City of Albuquerque Stormwater Construction Site Inspection Report

Project Name and Location	Ladera Crossing Silt Storage 1911 Ladera Dr NW		
Site Contact Name & Agency	Mike Tenney ARCO Murray	ESC File No. NPDES ID No.	1409E020 NMR10015F
Date of Inspection	12-7-18	Start/End Time	10:30/2:30
COA Inspector Name	Curtis Cherne, Stormwater Quality		
Describe Present Phase of Construction	Constructing wall, bldg, landscaping		
Type of Inspection:	<input checked="" type="radio"/> Regular • During storm event • Post-storm event (> 0.25 inch) • 311 / Complaint Response • Follow-Up

LADERA CROSSING SELF STORAGE

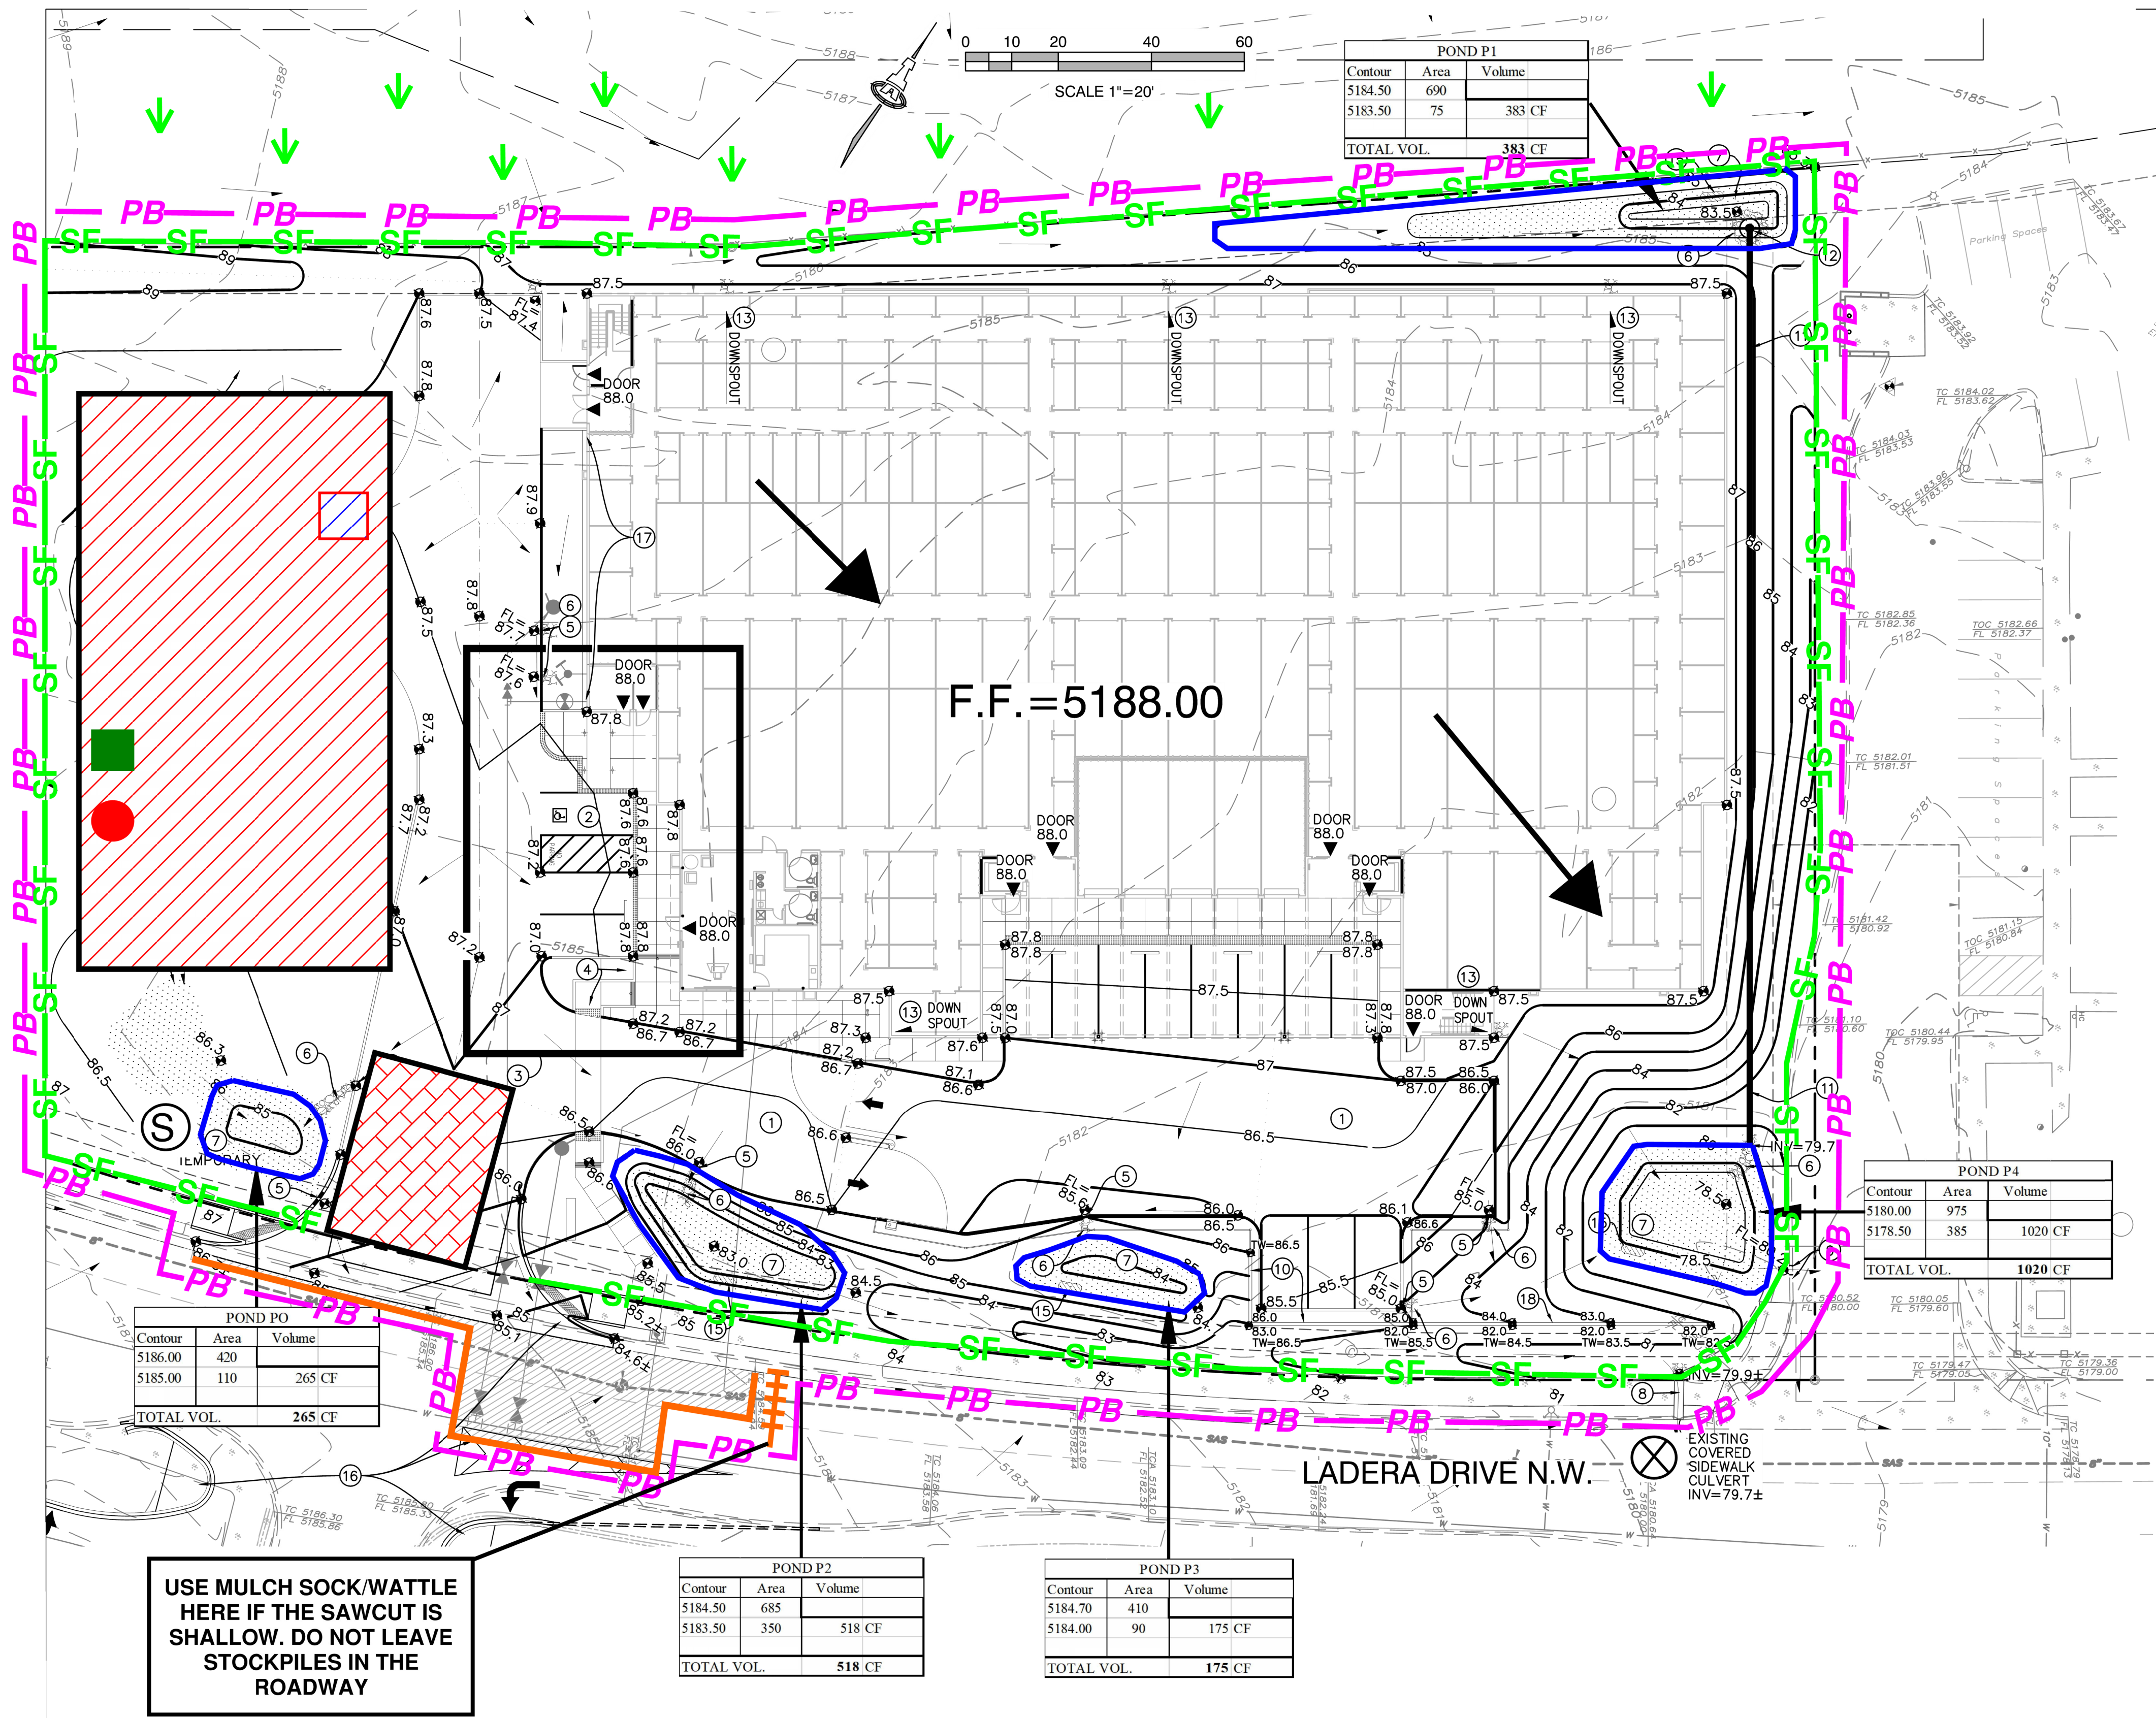
CGP ¹ Section	BMP / Activity	Maintenance or Corrective Action Required	Location and Notes
1.5	Post a Notice		
2.2.1	Provide and maintain Natural buffer when Waters of the US < 50 ft		
2.2.3	Sediment control along any perimeter	✓	gap in silt fence south edge
2.2.3	Sediment control along any perimeter	✓	silt fence maintenance/replacement east edge
2.2.3	Sediment control along any perimeter		gap
2.2.3	Sediment control along any perimeter		
2.2.3	Sediment control along any perimeter		
2.2.3	Sediment control along any perimeter		
2.2.3	Sediment control along any perimeter		
2.2.4	Minimize sediment track-out

2.3.3	Fuel, oil, hydraulic fluid, petroleum products and chemical storage		
2.3.3	Construction and Domestic Wastes	✓	litter in parking area
2.3.3	Construction and Domestic Wastes

2.3.4	Washing Applicators used for paint, stucco, concrete, etc.	✓	wash-out SW parking Island
2.3.4	Washing Applicators used for paint, stucco, concrete, etc.	✓	washout south portion of site

2.3.4	Washing Applicators used for paint, stucco, concrete, etc.	✓	no wash-out facility
2.4	Dewatering		
2.1	Discharge off site?	• Yes • <u>No</u>	
4	Self-Inspection Reports	request	Latest Report Date: 9-25-18 in book
